Application Ref: H17-1097-23

Proposal: **Proposed plant based protein extraction facility and anaerobic digester plant**

Location: **Land East of Surfleet Bank and West of Woad Farm, PE11 4DP**

Requests that the Local Planning Authority request the applicants to provide additional information as set out below.

1:1000 Site plan Key

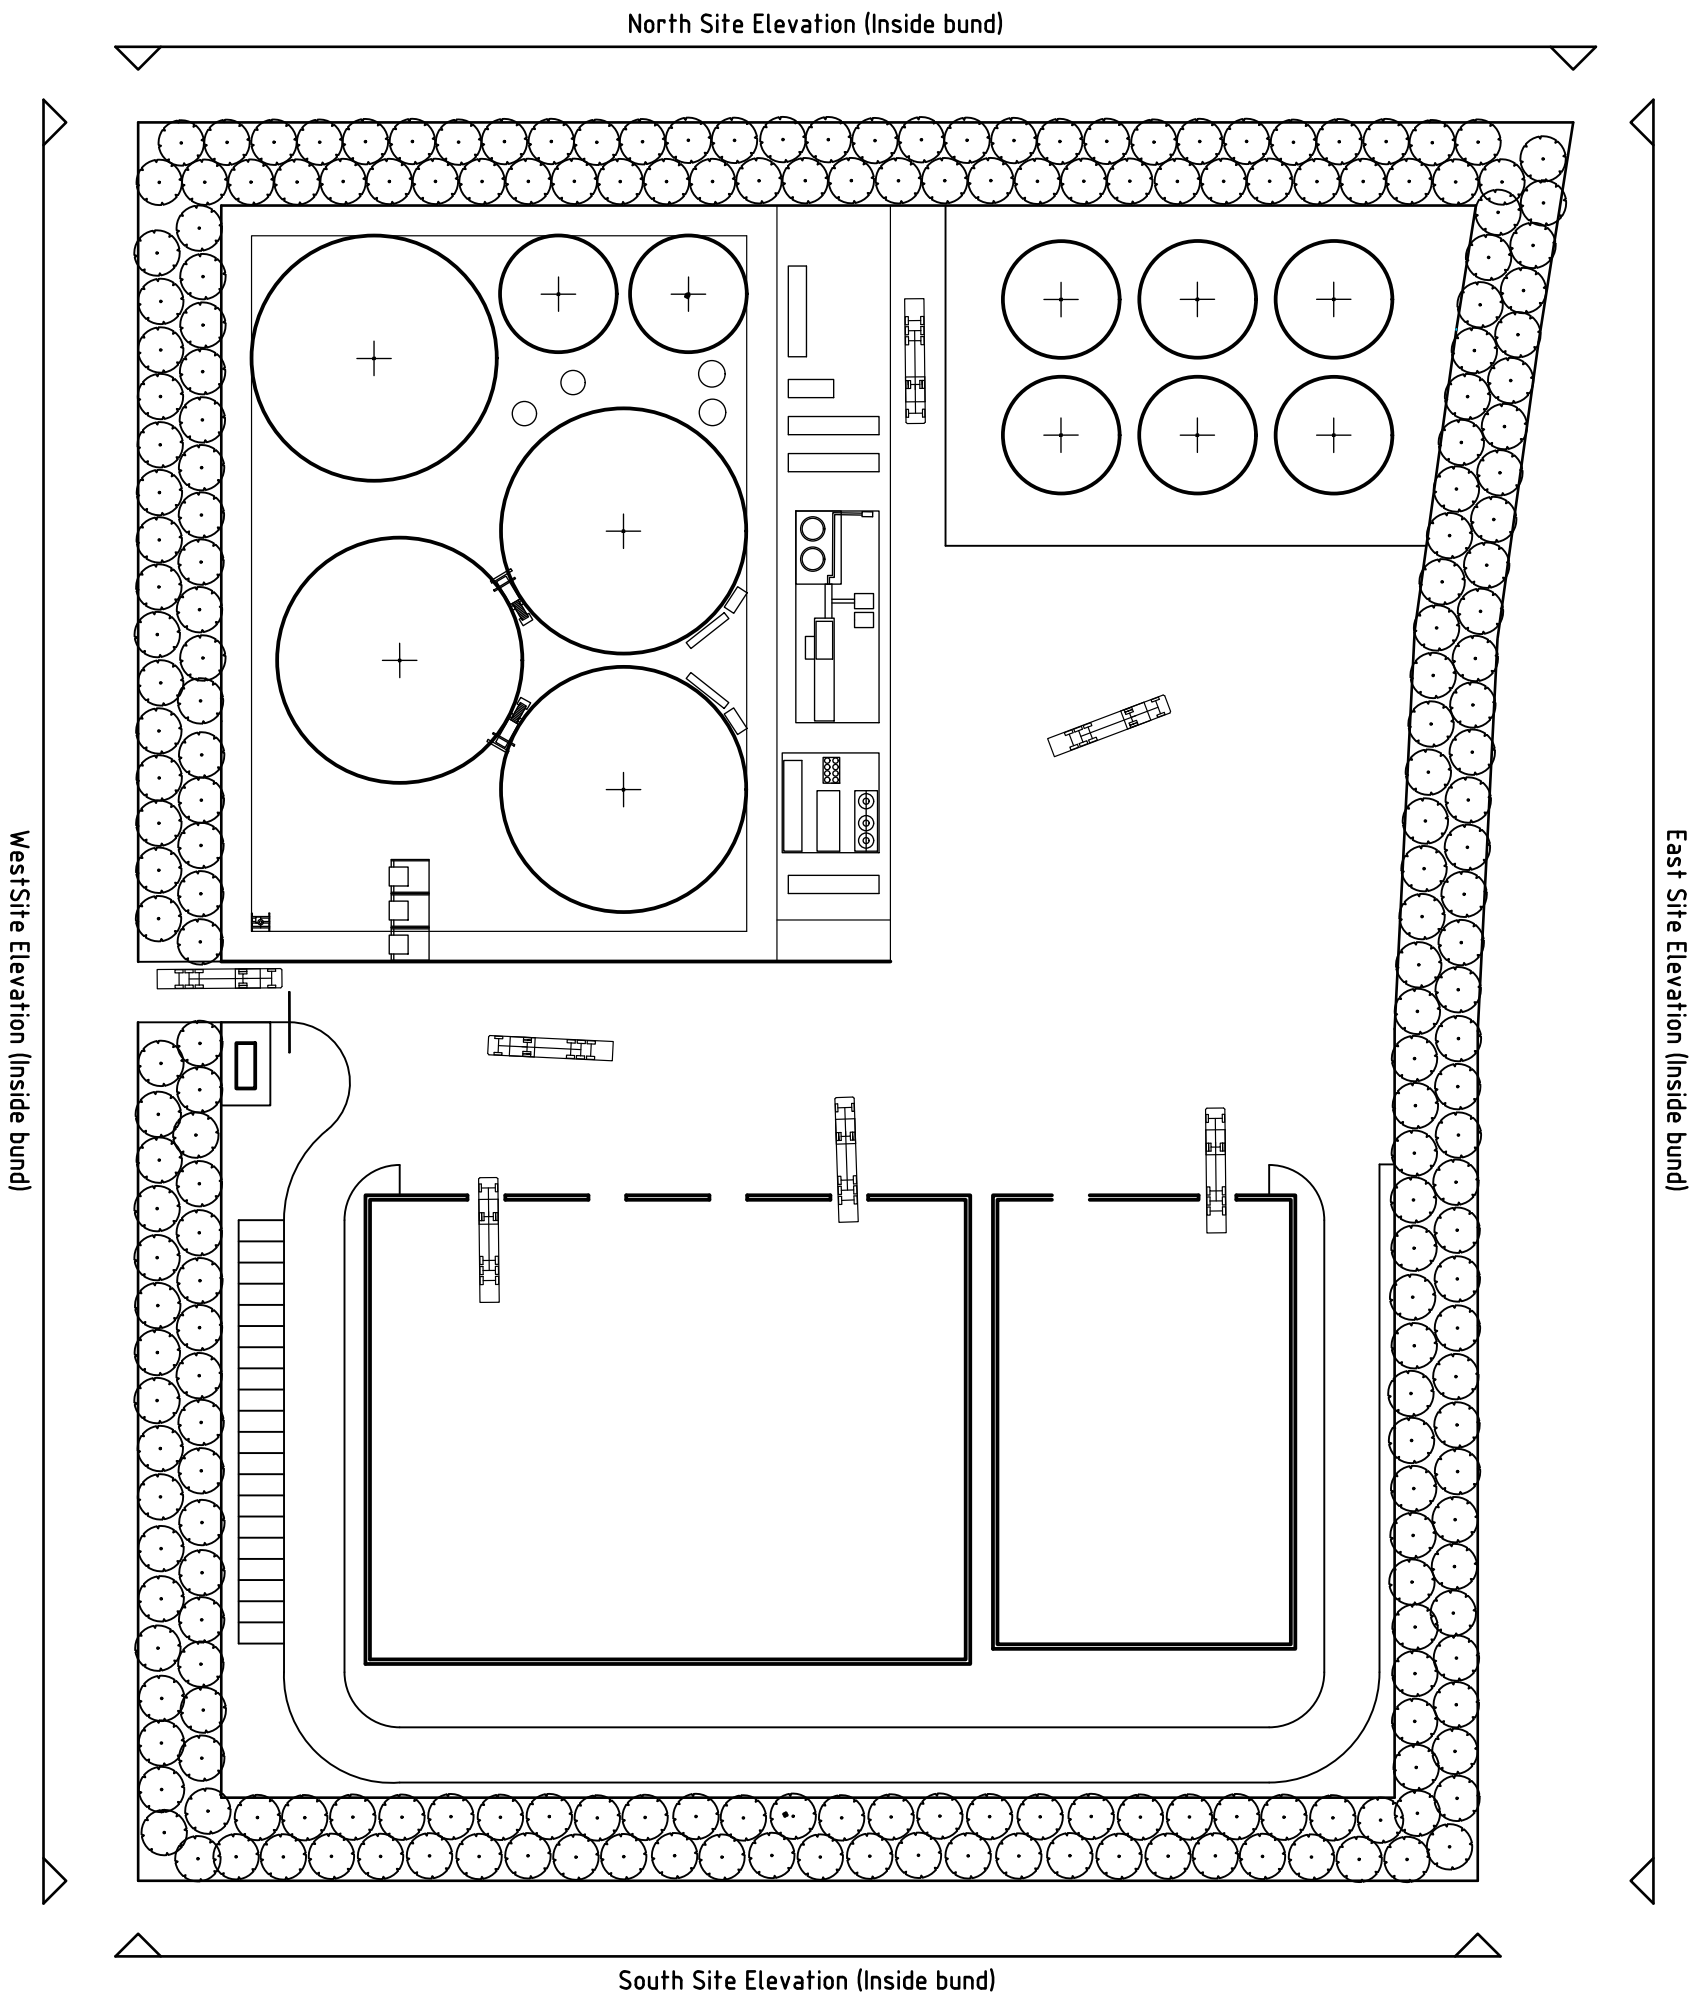
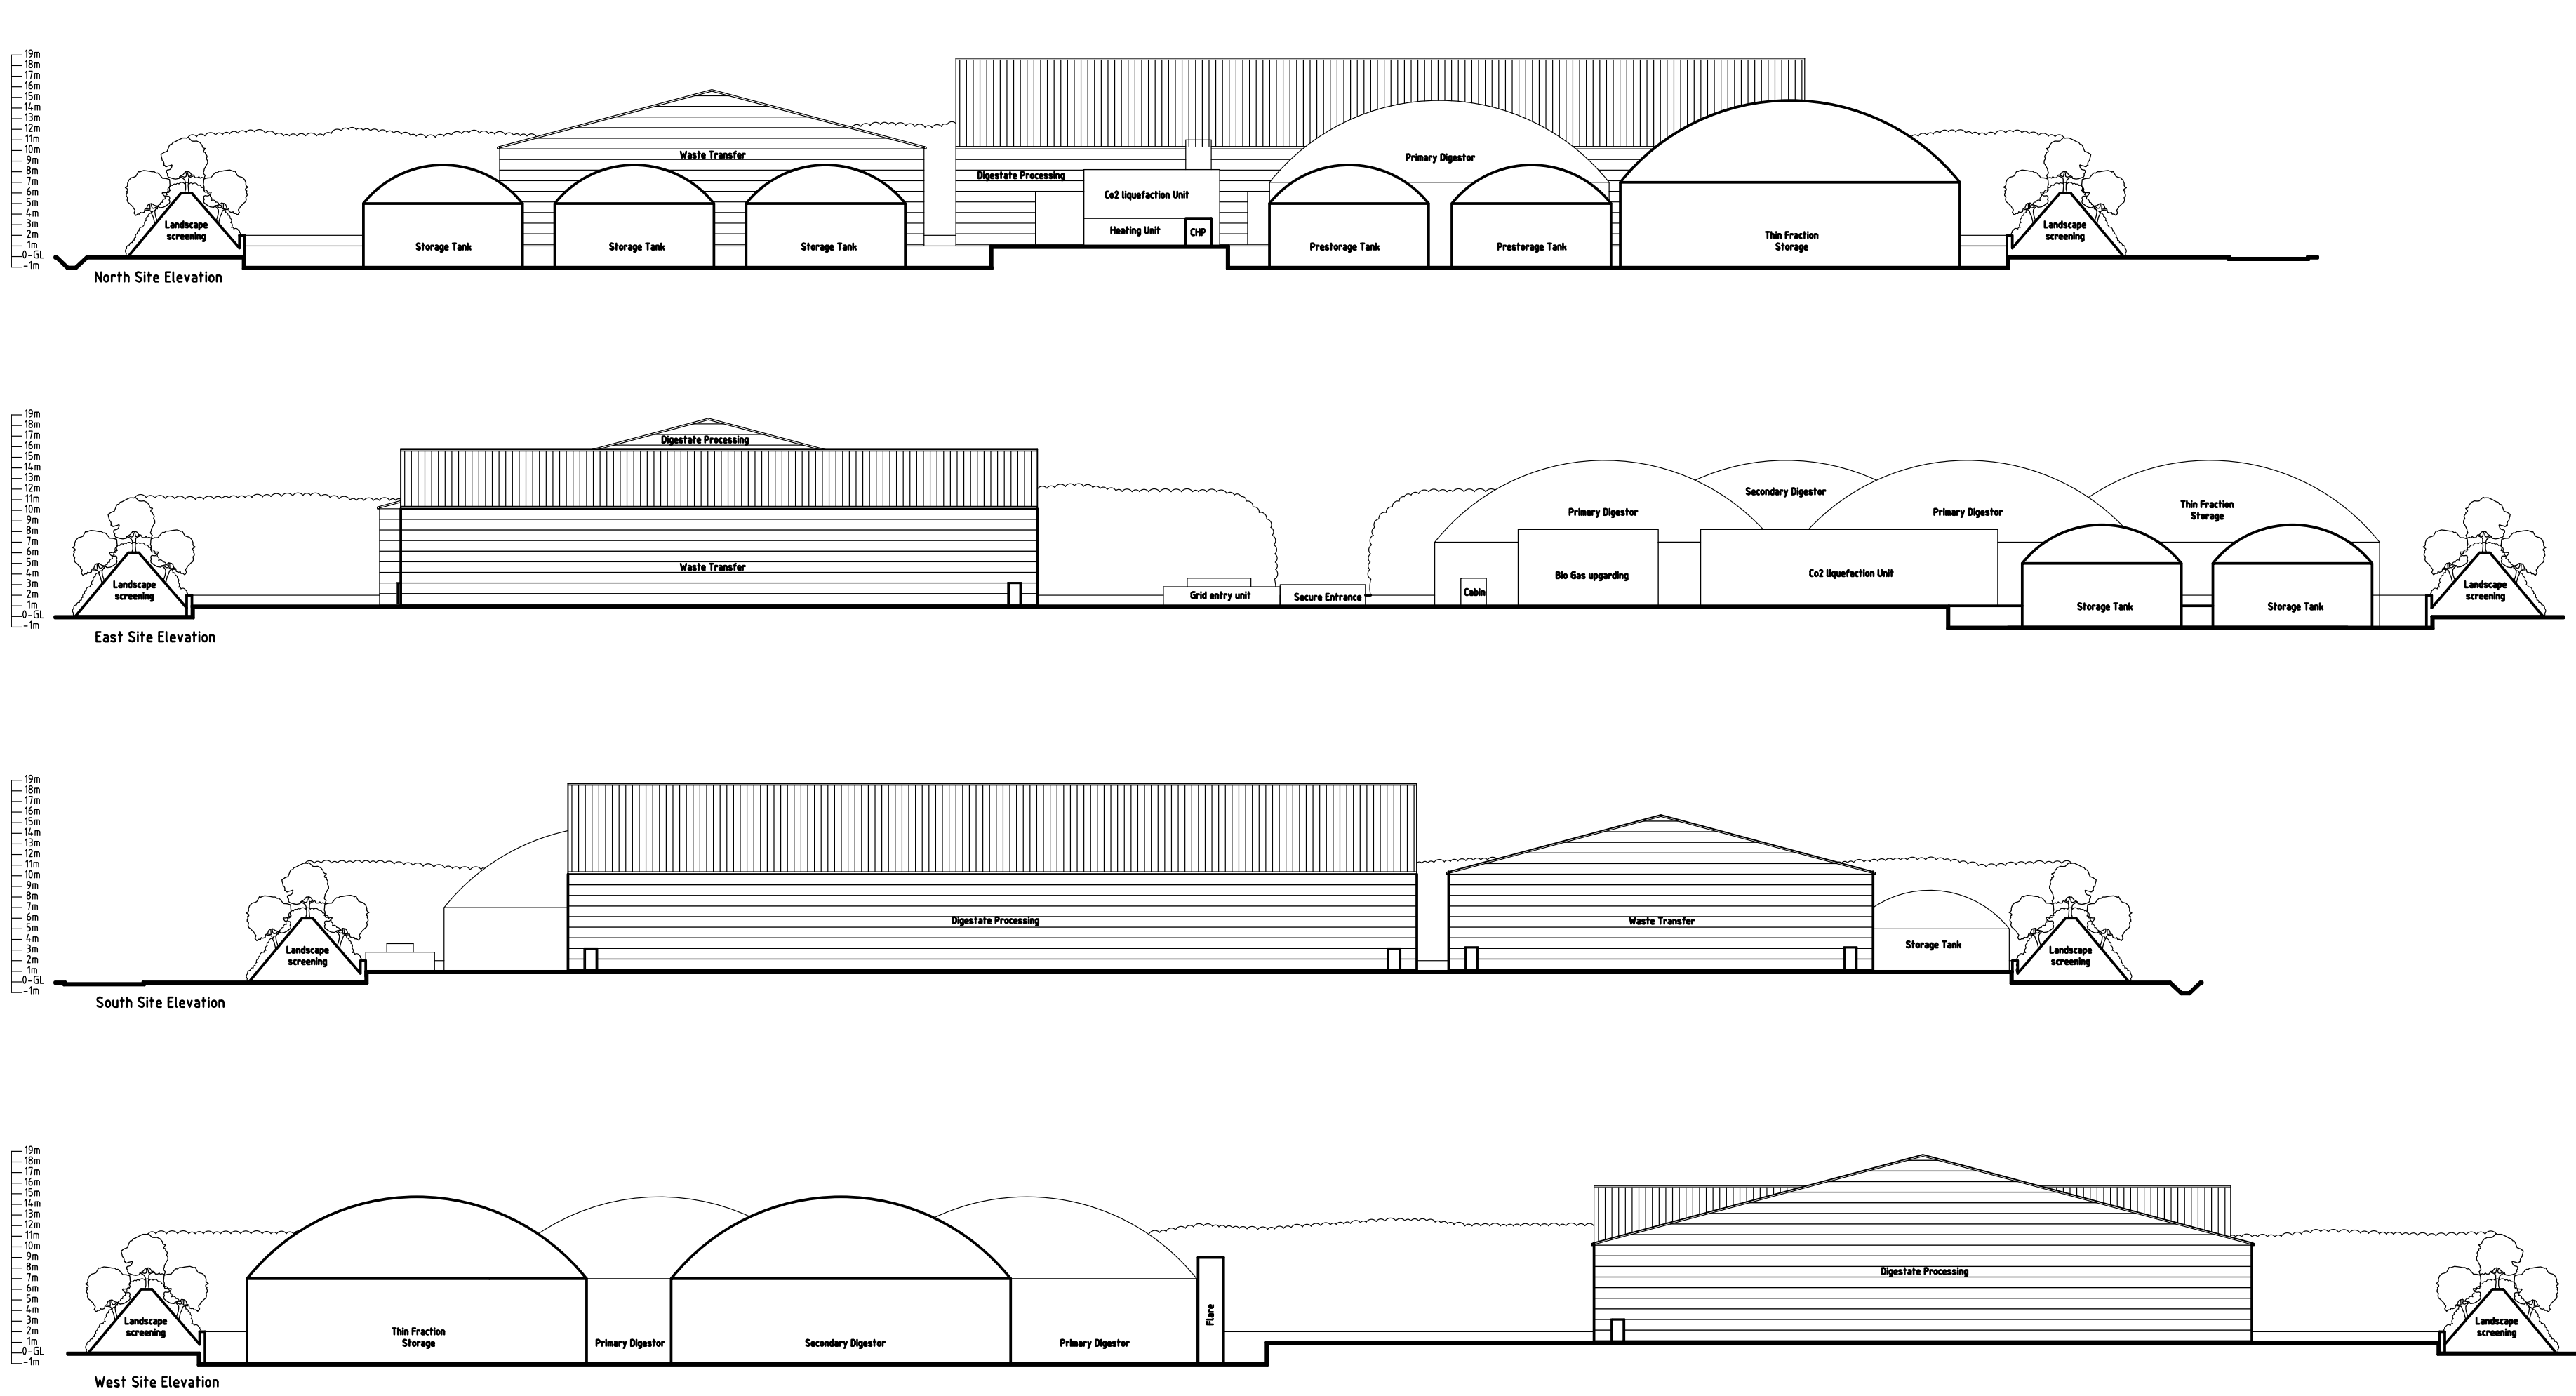
The access will need upgrading and a note should be added to the proposed site plan to say it will be constructed to Lincolnshire County Council Specification.
